Application for Removal or Variation of a Condition following Grant of Planning Permission or Listed Building Consent

Section 73 application to vary planning condition no. 14 to vary visibility splay to 2.4m by 22m to the right (southbound traffic) and 2.4m by 24m to the left (northbound traffic). Condition no. 2 would have to be varied as a result to refer to a new visibility splay drawing and layout drawing with the amended splay oin.

3/2022/0537

Drawing Title: VISIBILITY SPLAY

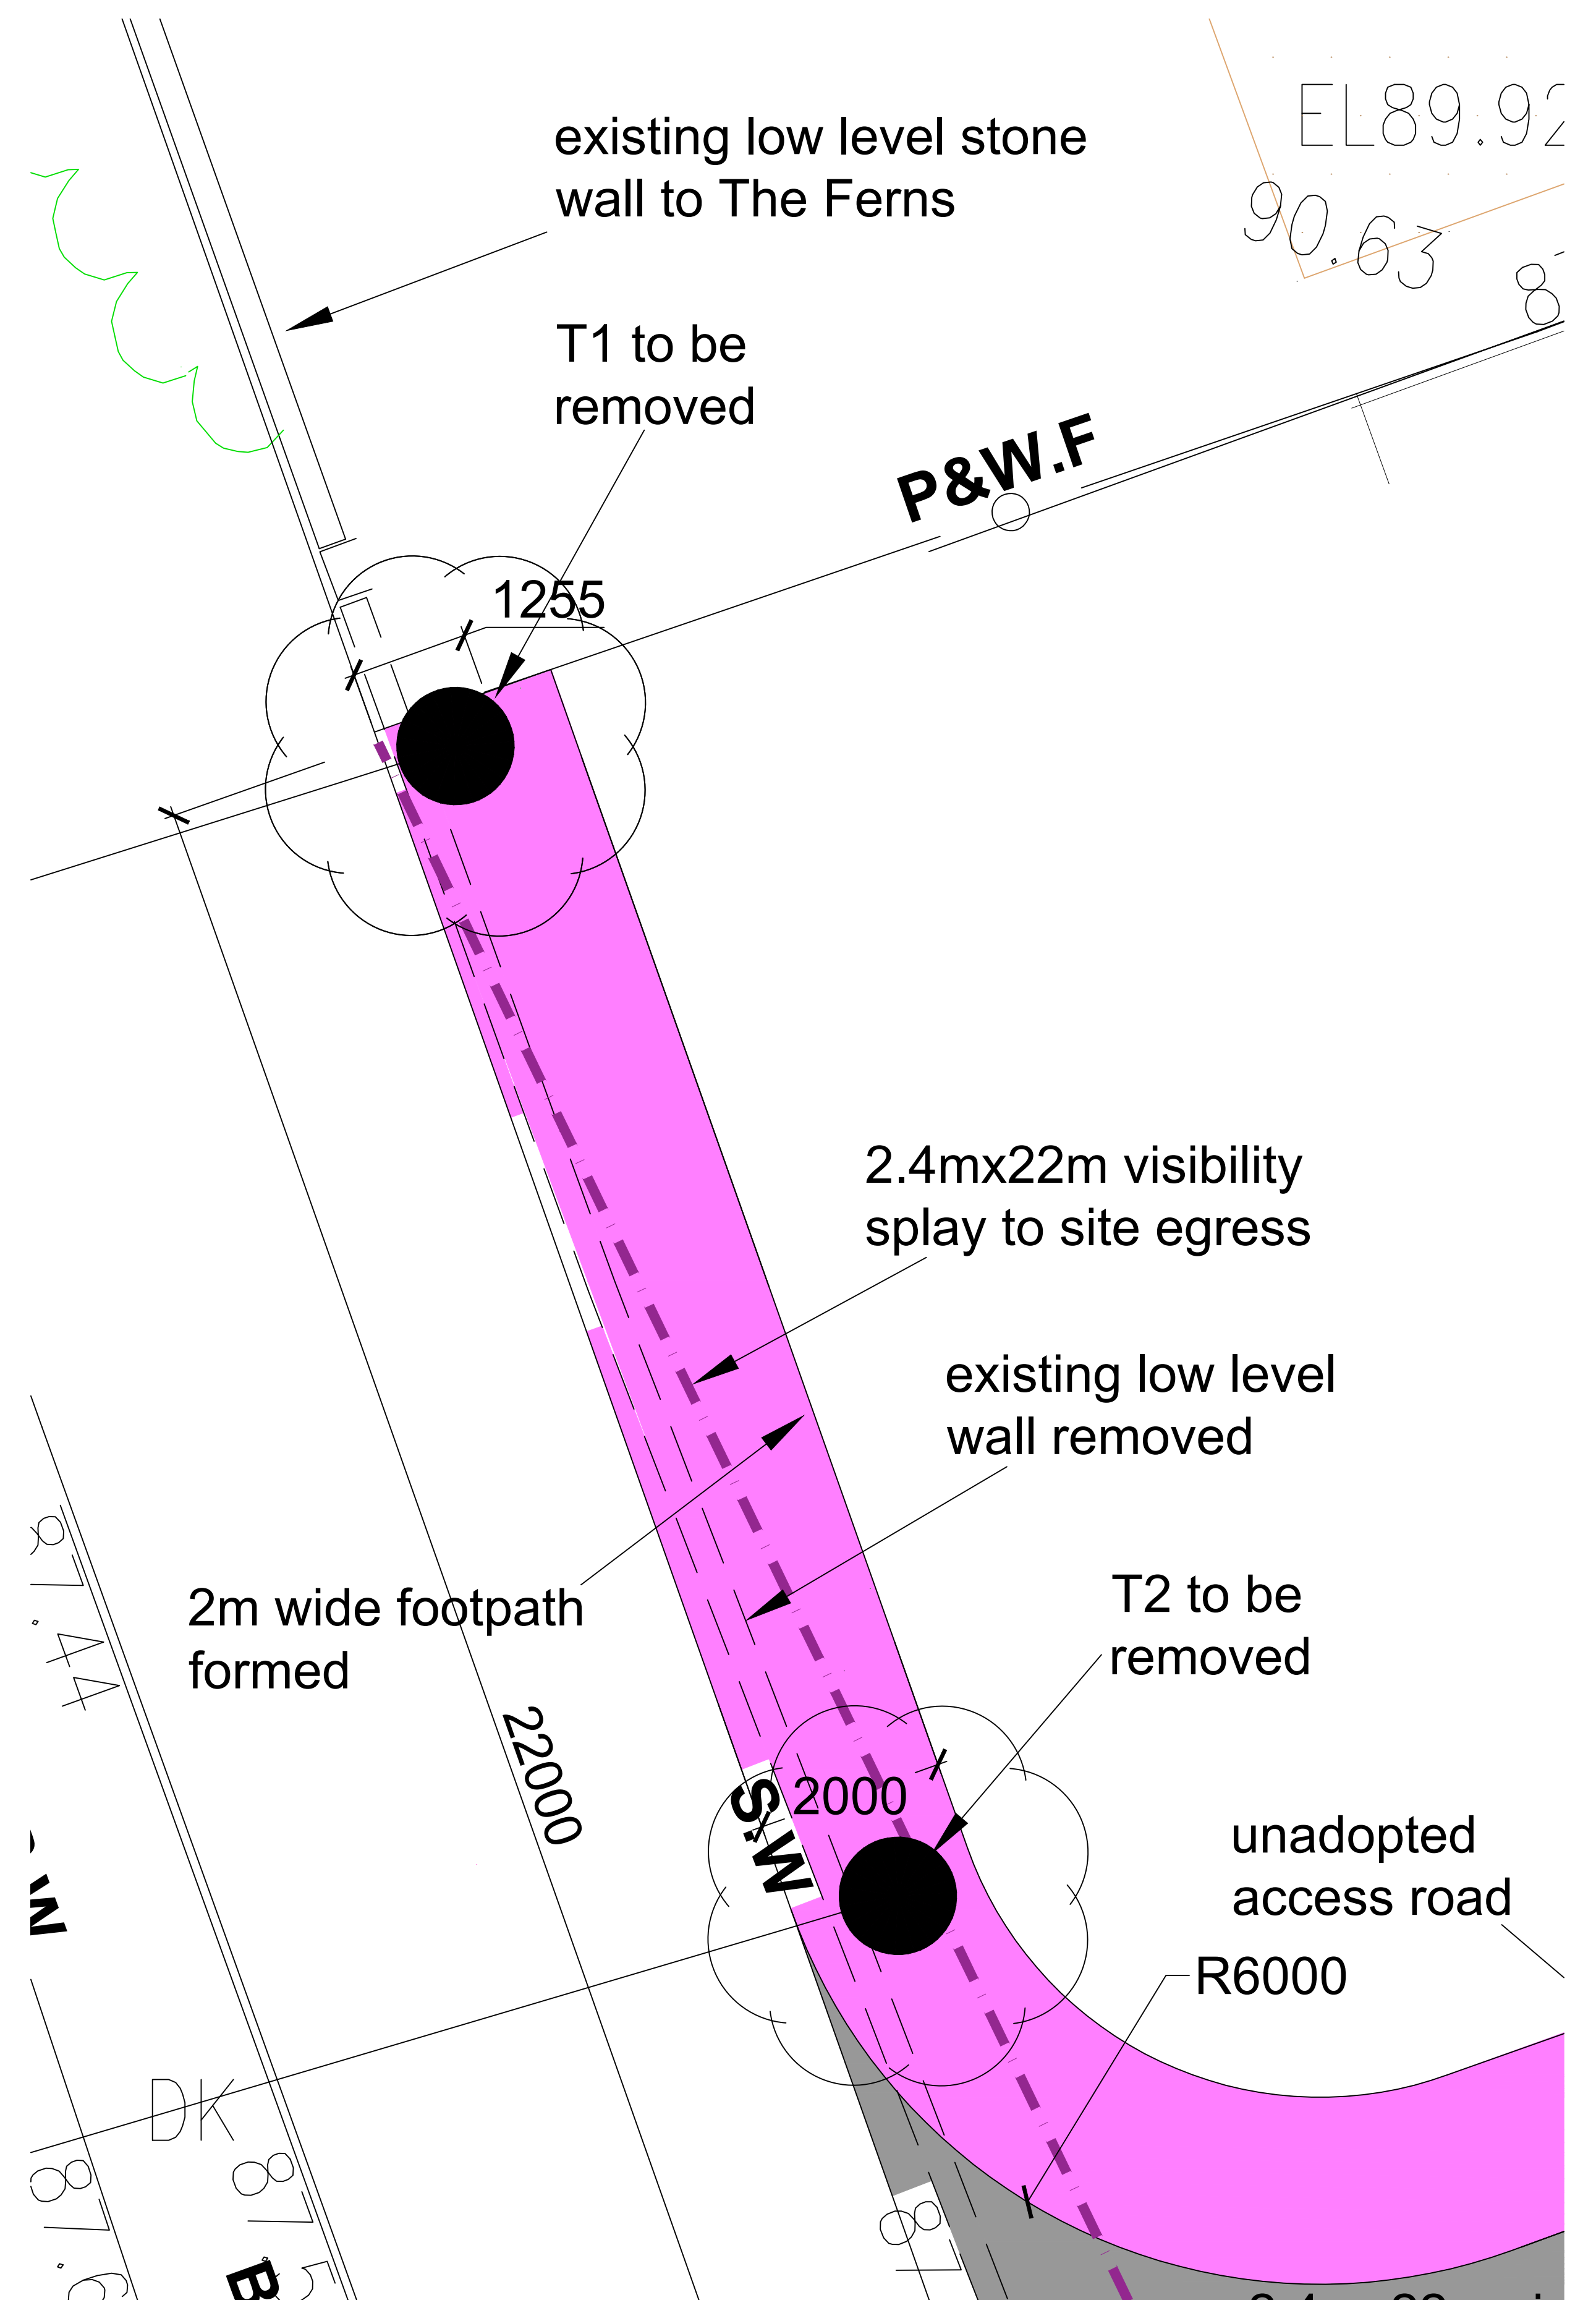
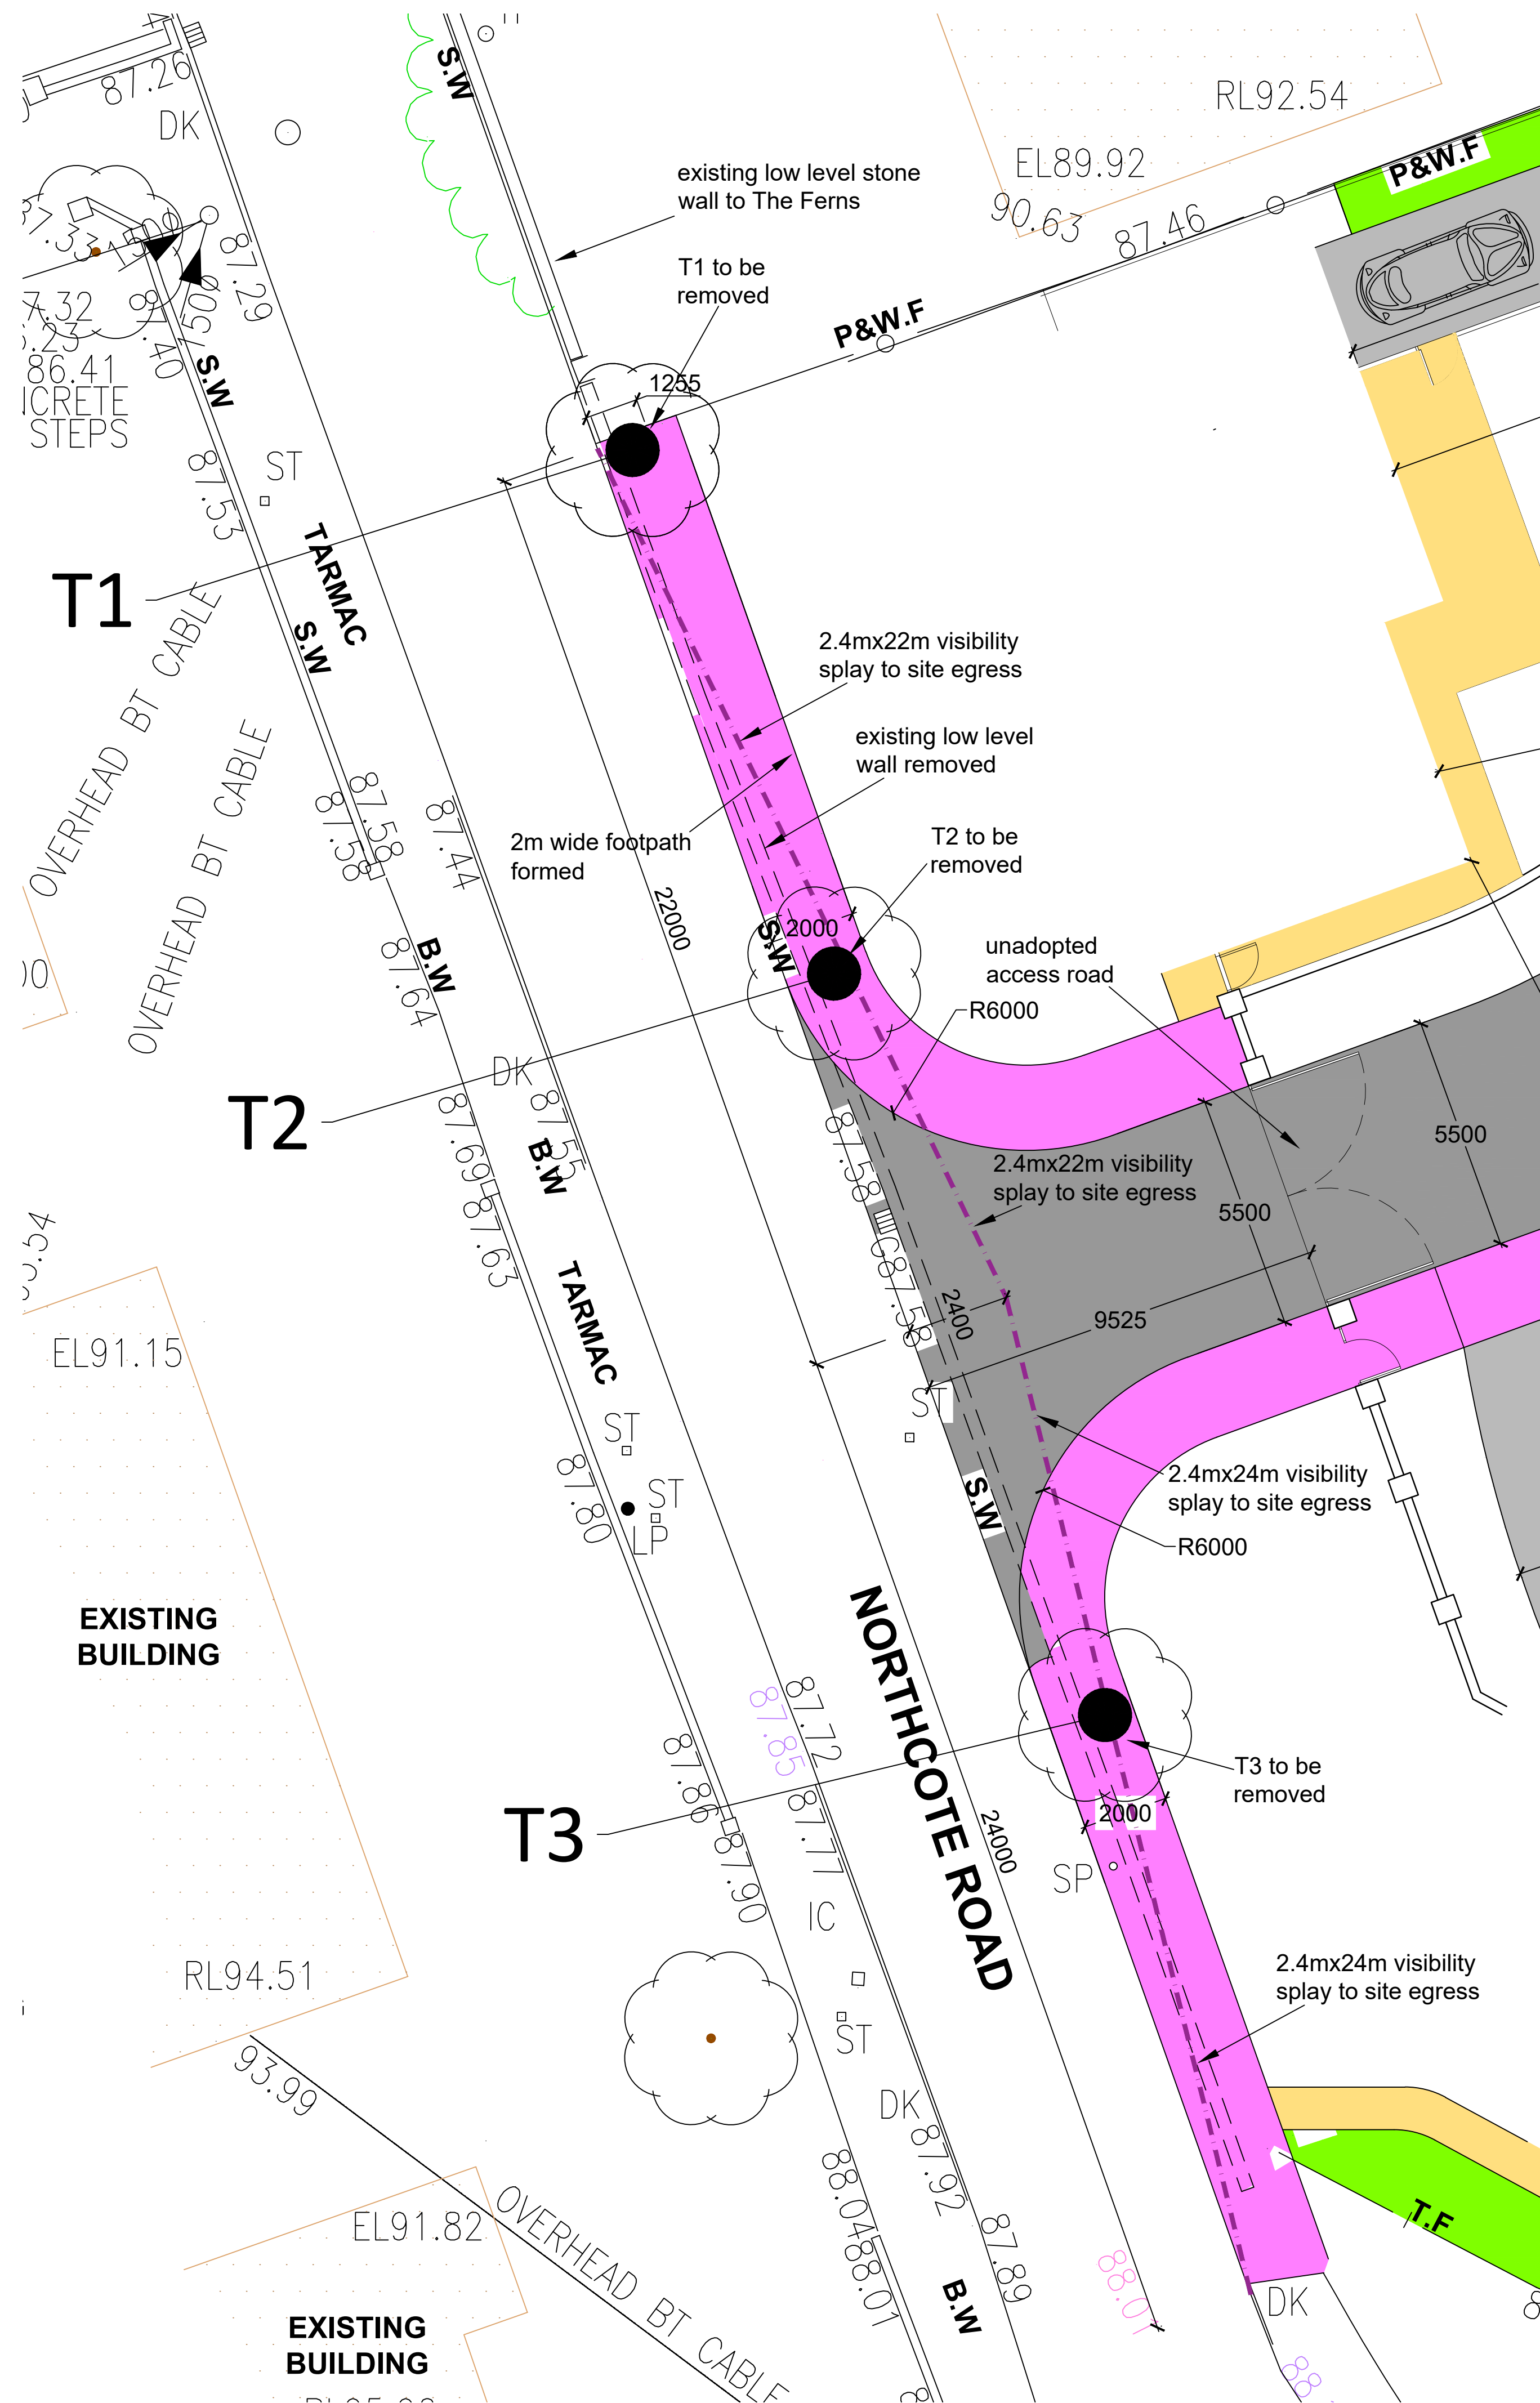
To provide for reduced visibility splay as agreed with the highway officer.
